**DEPARTMENT OF PLANNING & INFRASTRUCTURE – STATE SIGNIFICANT
DEVELOPMENT 5300 – LOT 10 DP 878167 – RESOURCE RECOVERY FACILITY, KEMBLA
GRANGE – DRAFT ENVIRONMENTAL IMPACT STATEMENT**

REVIEW OF DRAFT ENVIRONMENTAL IMPACT STATEMENT – VERSION 2 - RESOURCE RECOVERY FACILITY – KEMBLA GRANGE (SSD 5300)

Comments on the revised Draft Environmental Impact Statement for the Resource Recovery Facility, Kembla Grange

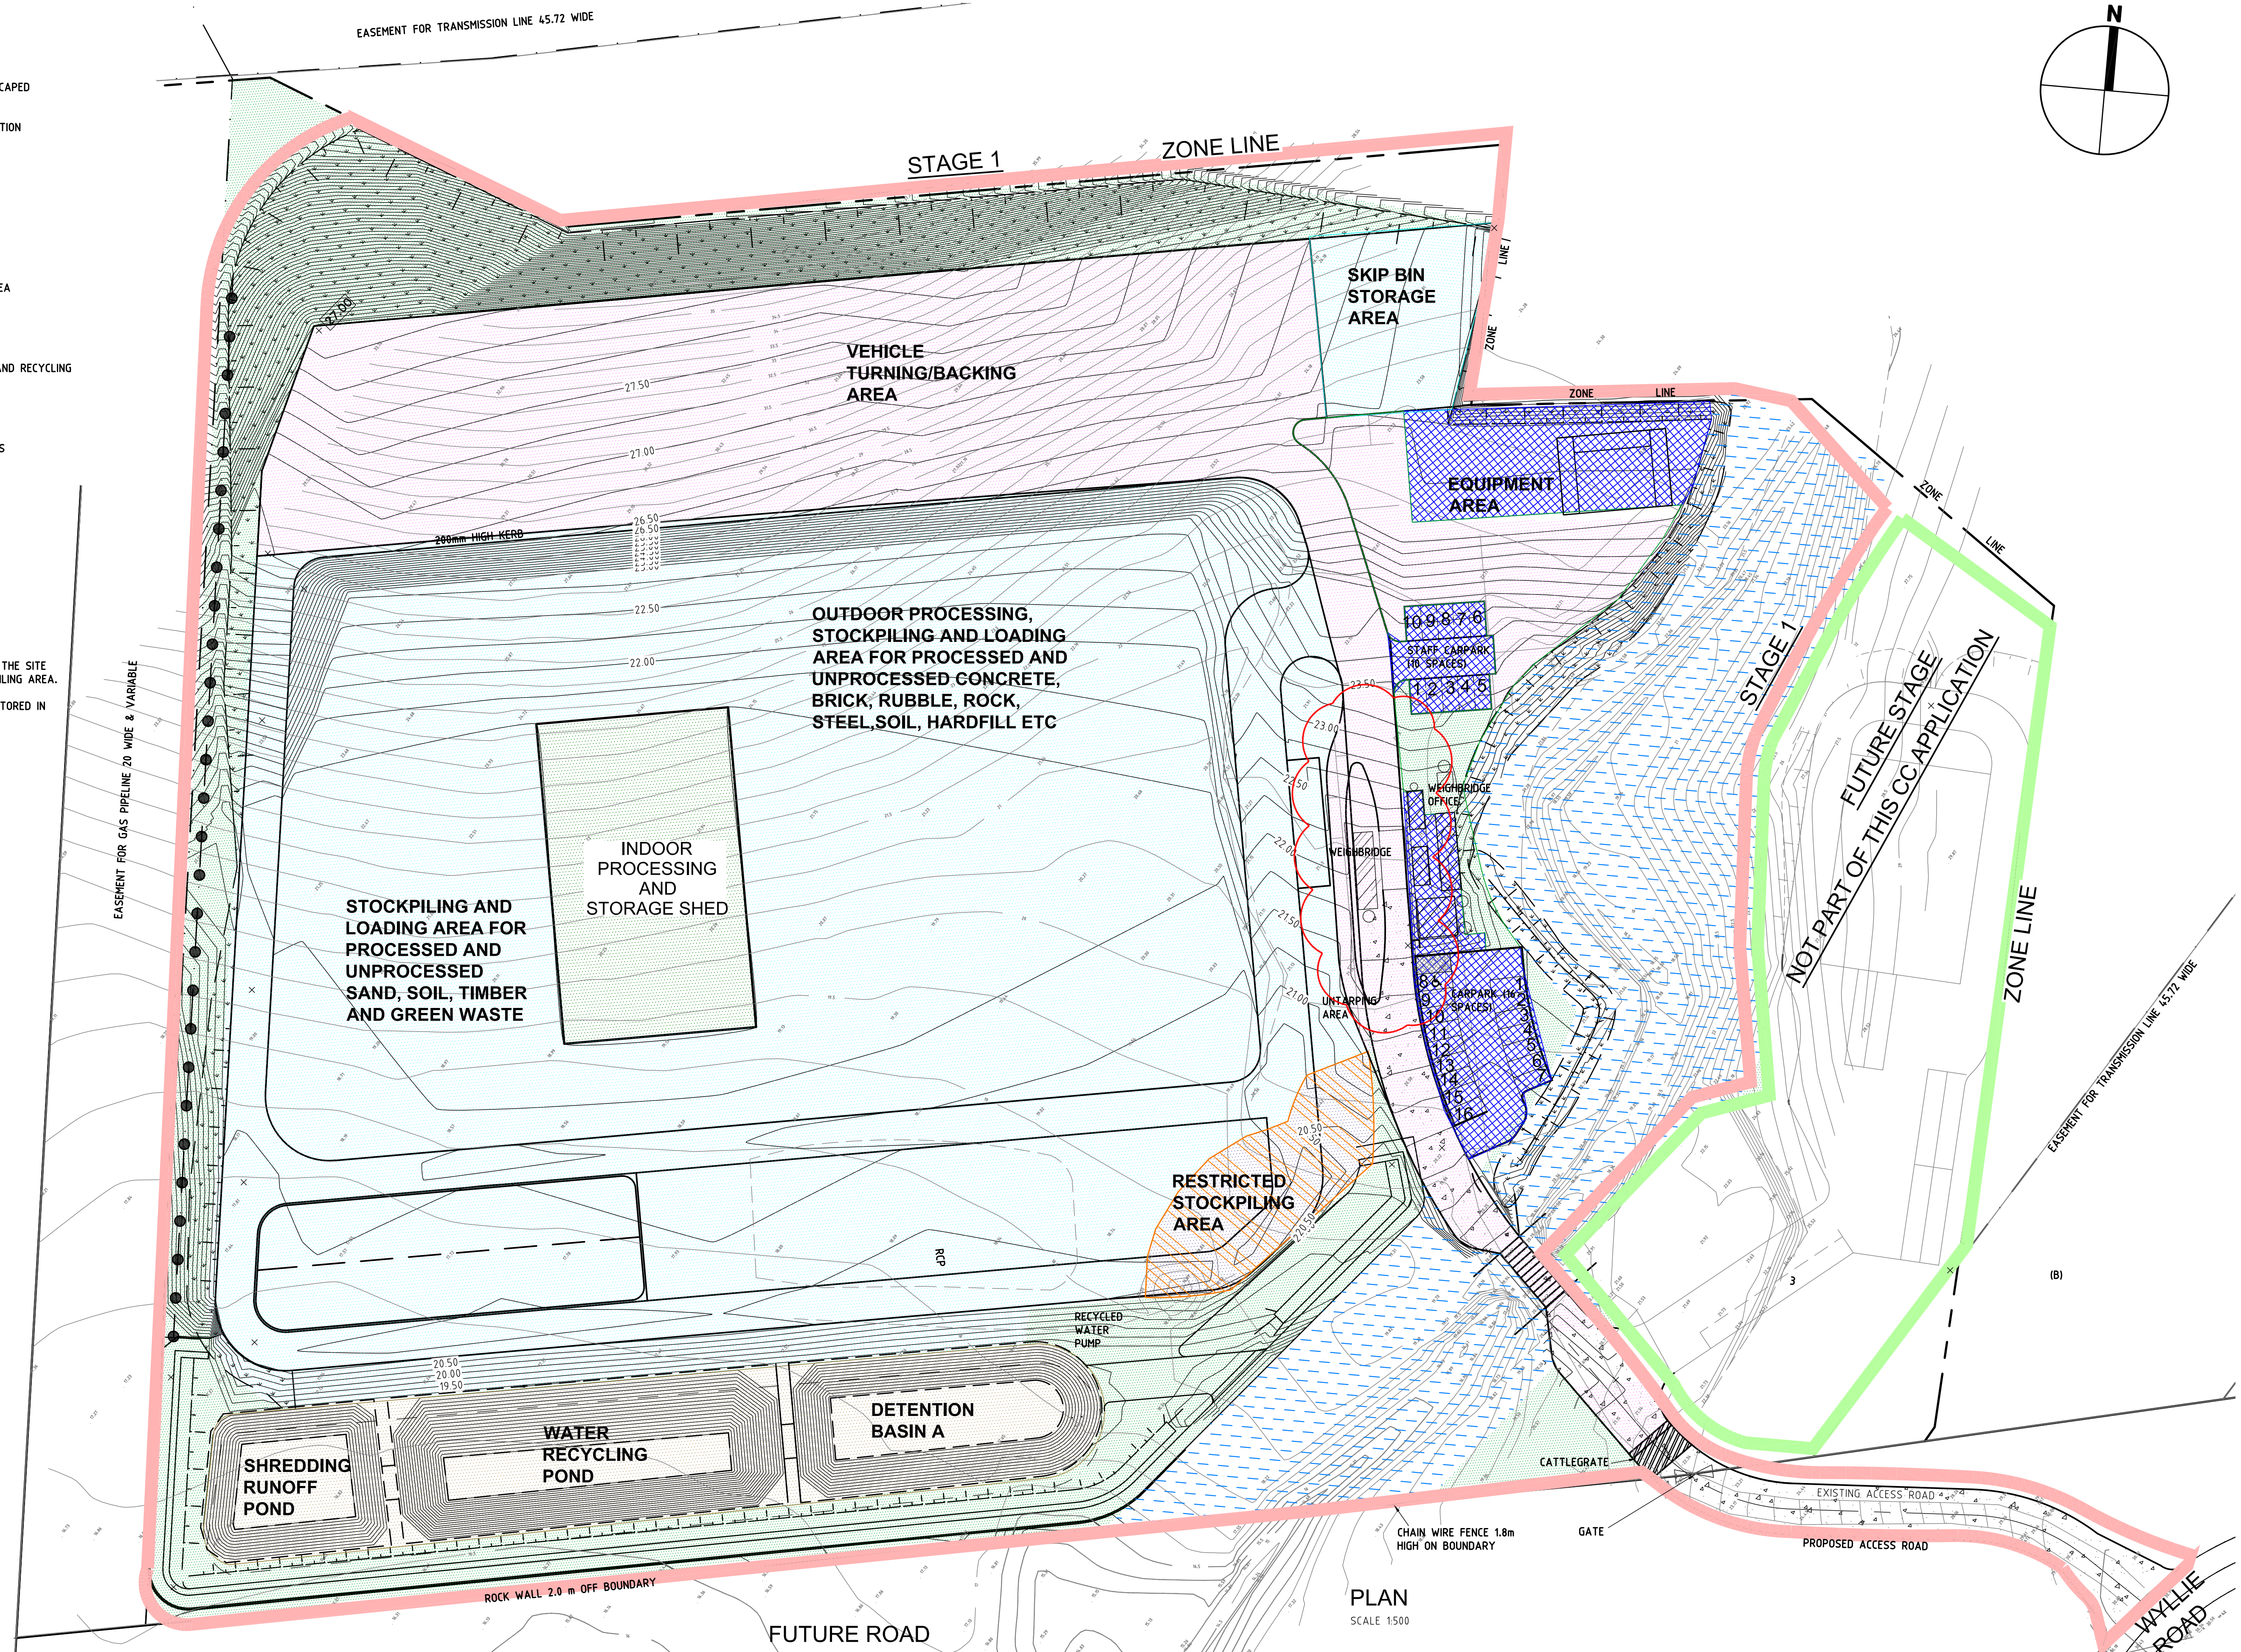
Flood inundation plans prepared by KFW indicate that part of the stockpile area is inundated by flooding during a PMF flood event. In this respect documentation submitted in support of this application has not detailed measures to be implemented that will prevent these stockpiled materials from being transported from the development site during this flood event. The KFW soil and water management details are insufficient for this occurrence.

STORMWATER DRAINAGE PLAN

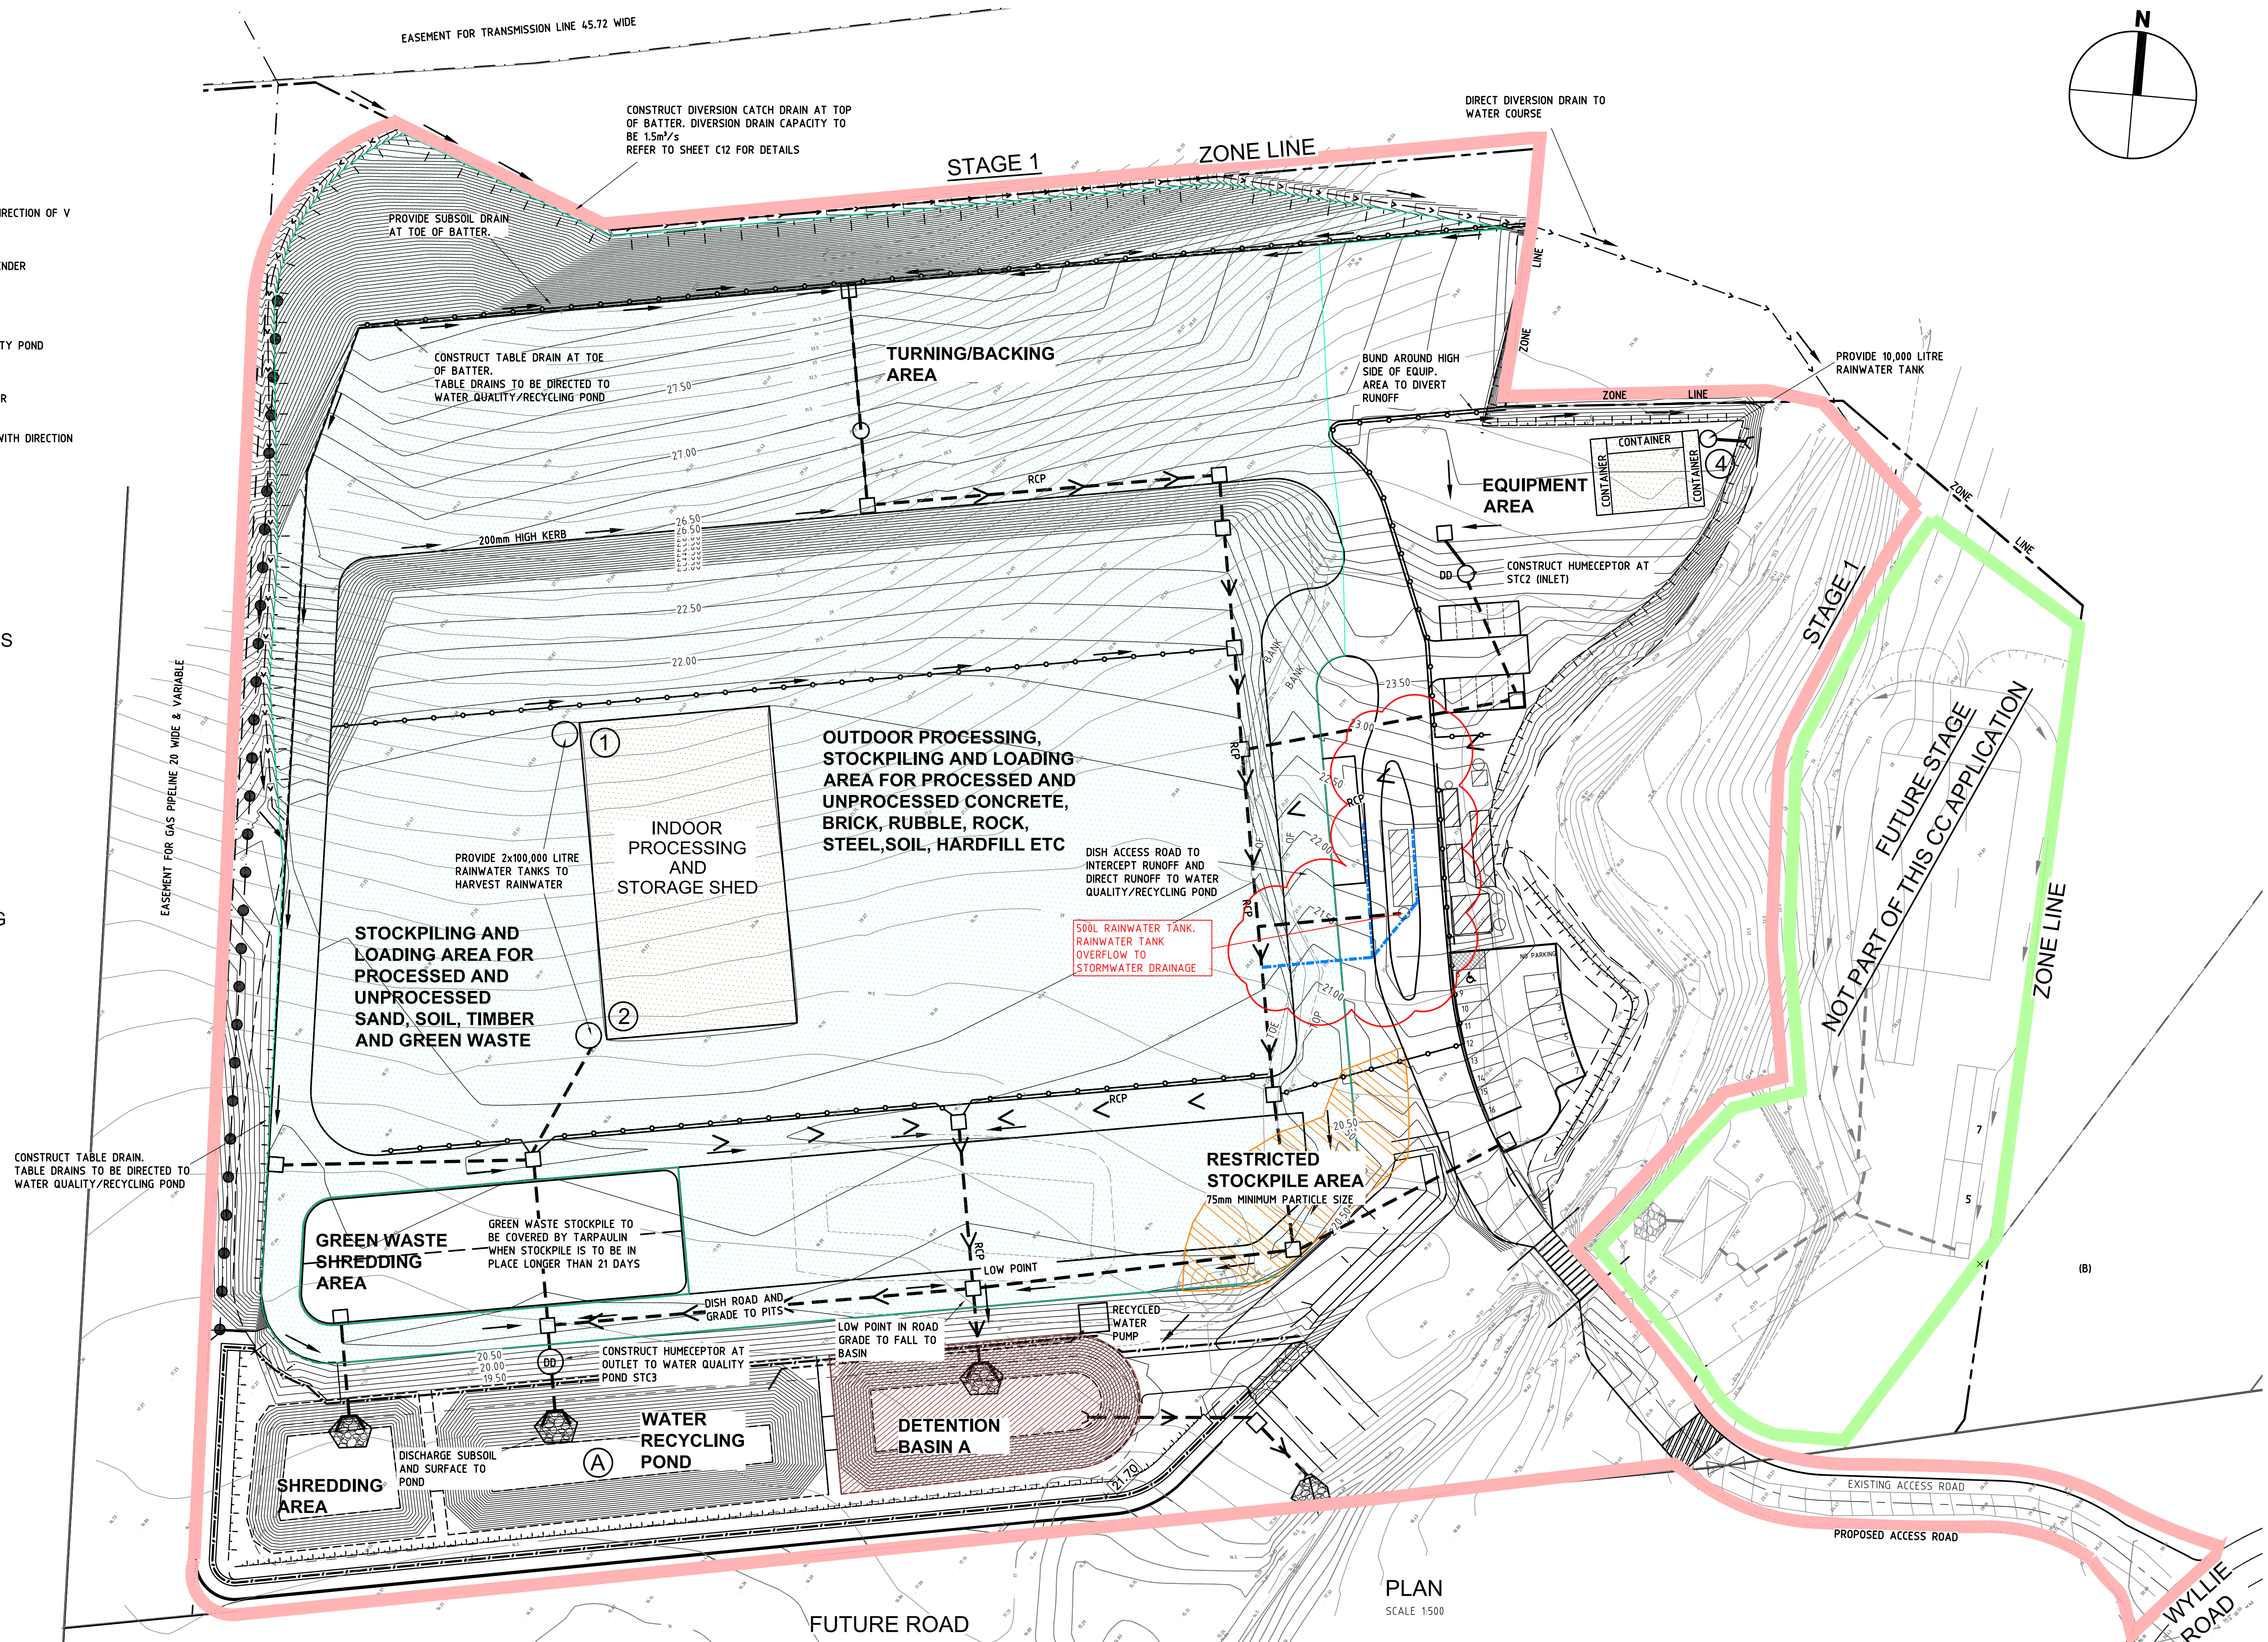
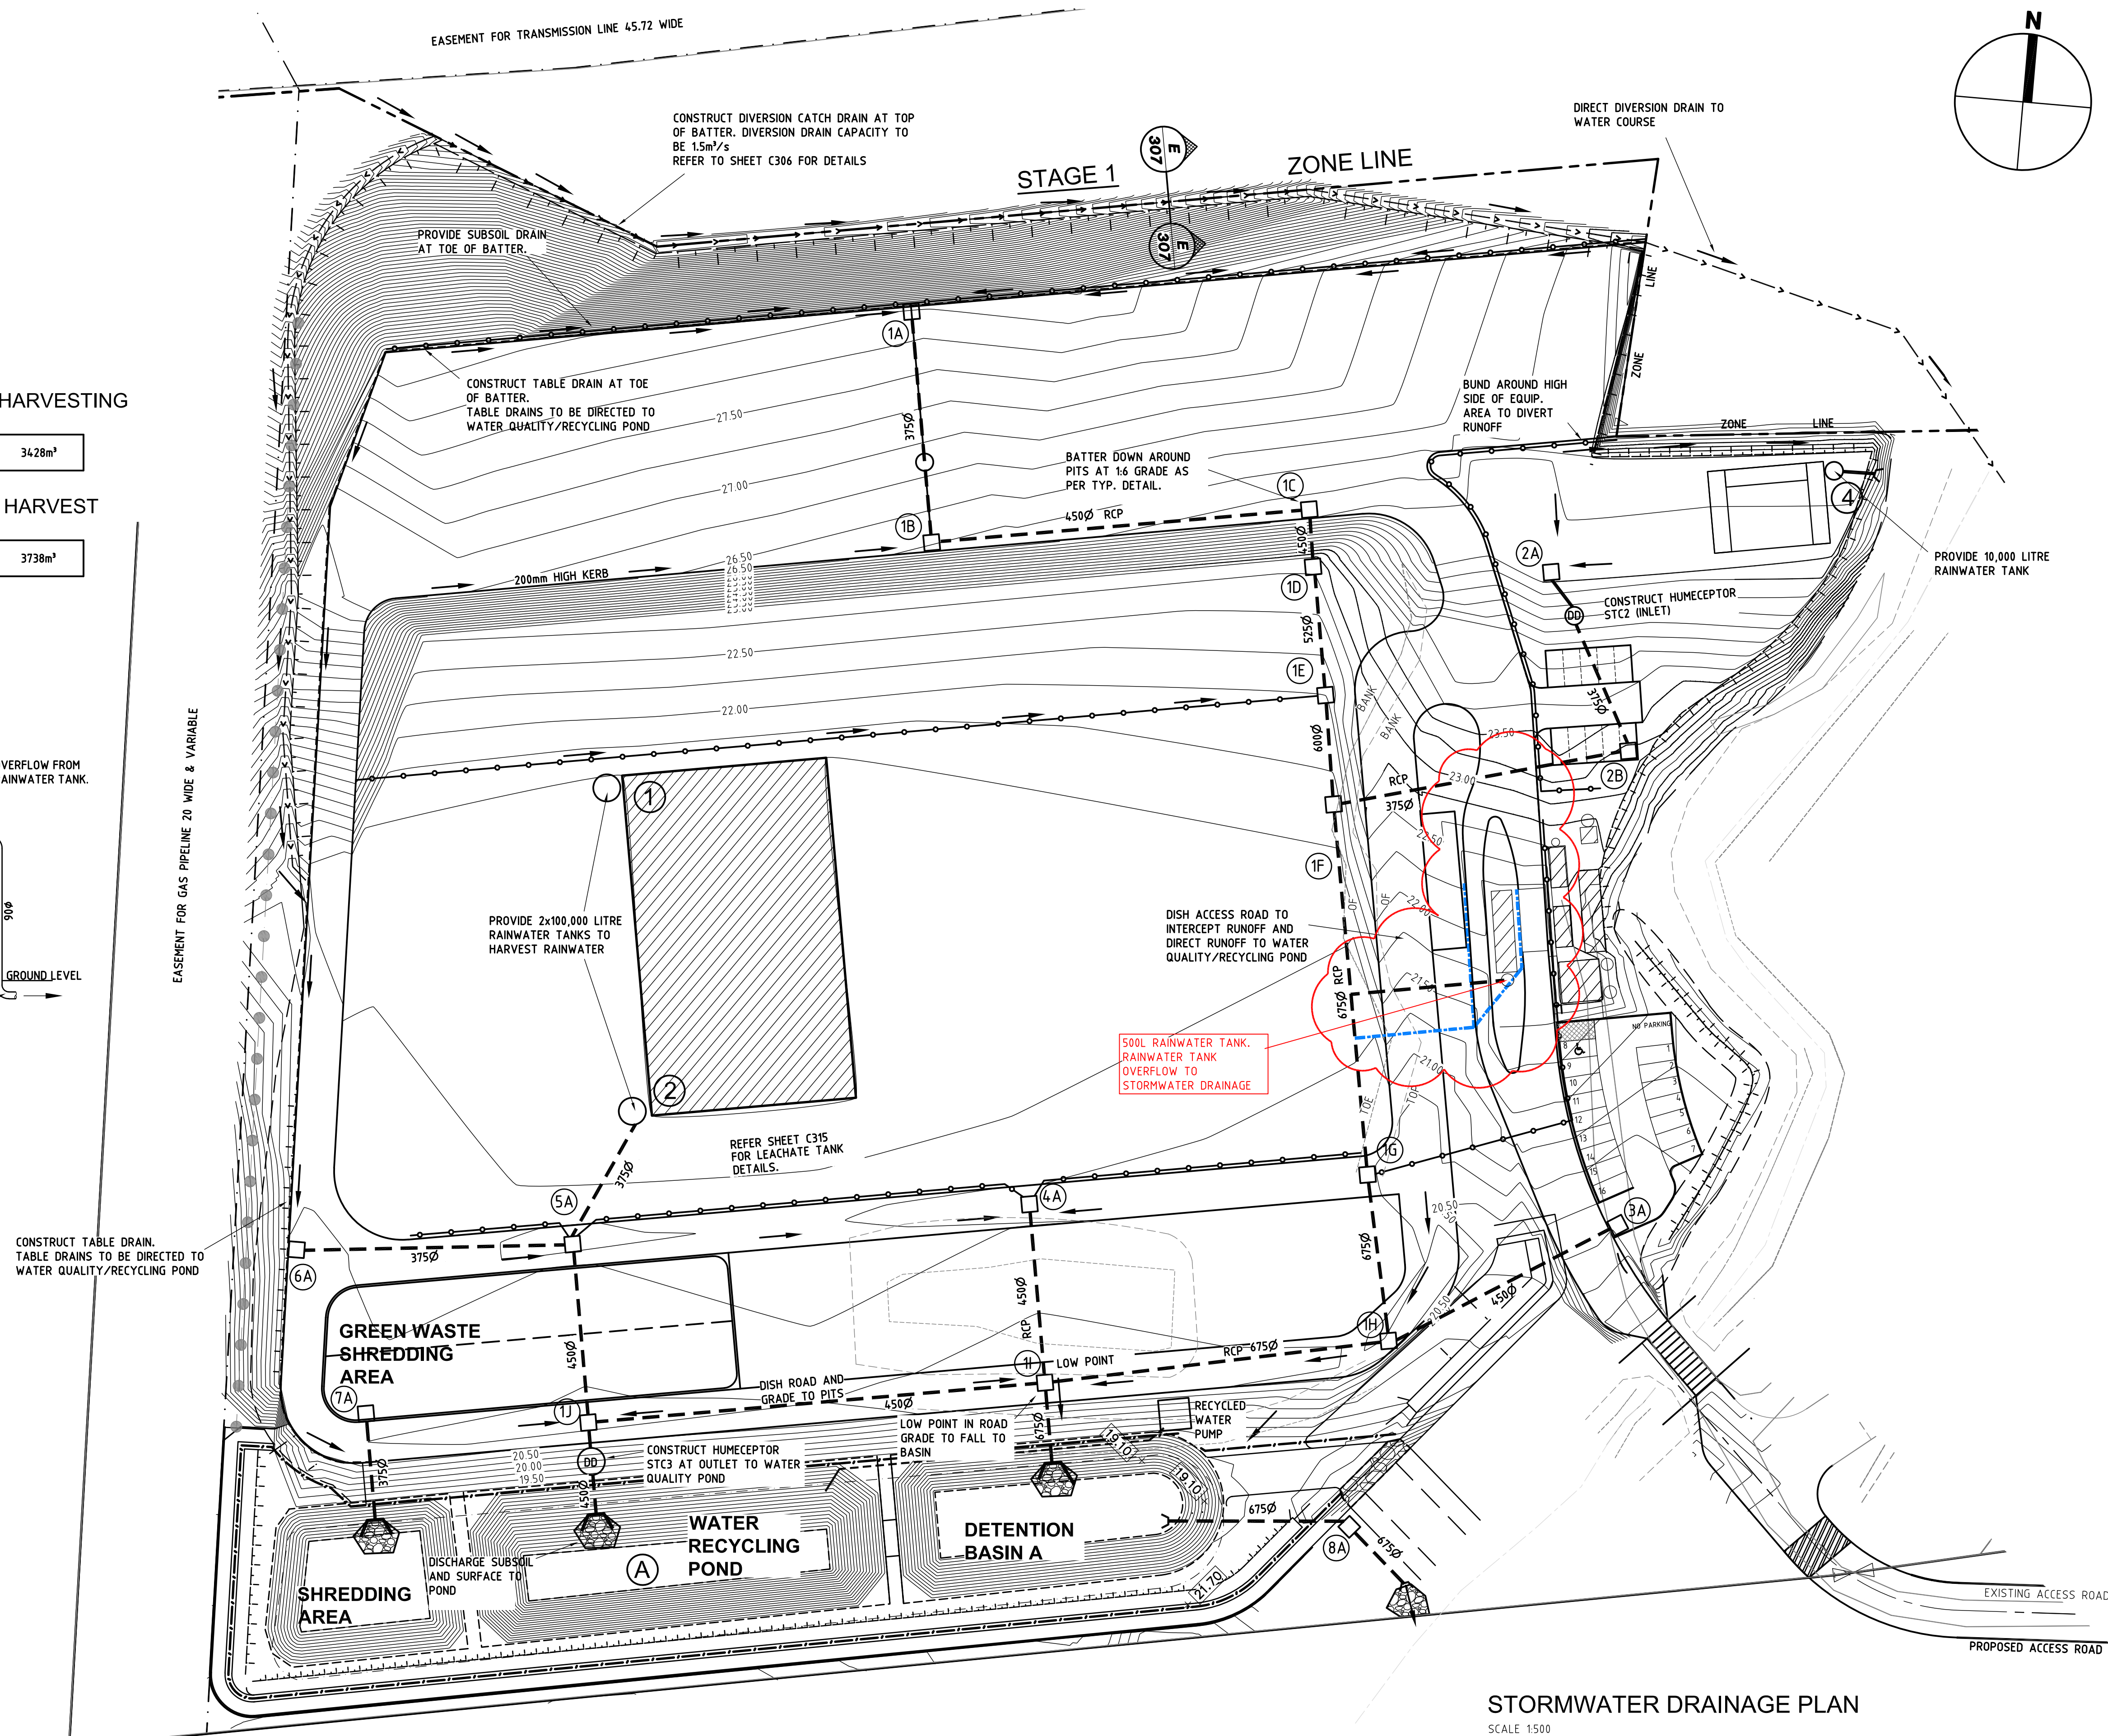
An examination of the stormwater layout on the Site, Pond Details and Soil & Water Management Plans in the KFW WSUD Strategy report has revealed that these plans are inconsistent with the stormwater layout on the Site Plan-Proposed Layout-Flood Lines and the Site Plan – Proposed Layout Plans in the KFW Flood analysis Review. All plans submitted in support of this development should have consistent stormwater management layout plans. In connection to this matter the method of stormwater connection into the watercourse must also be consistent throughout the full drawing set.
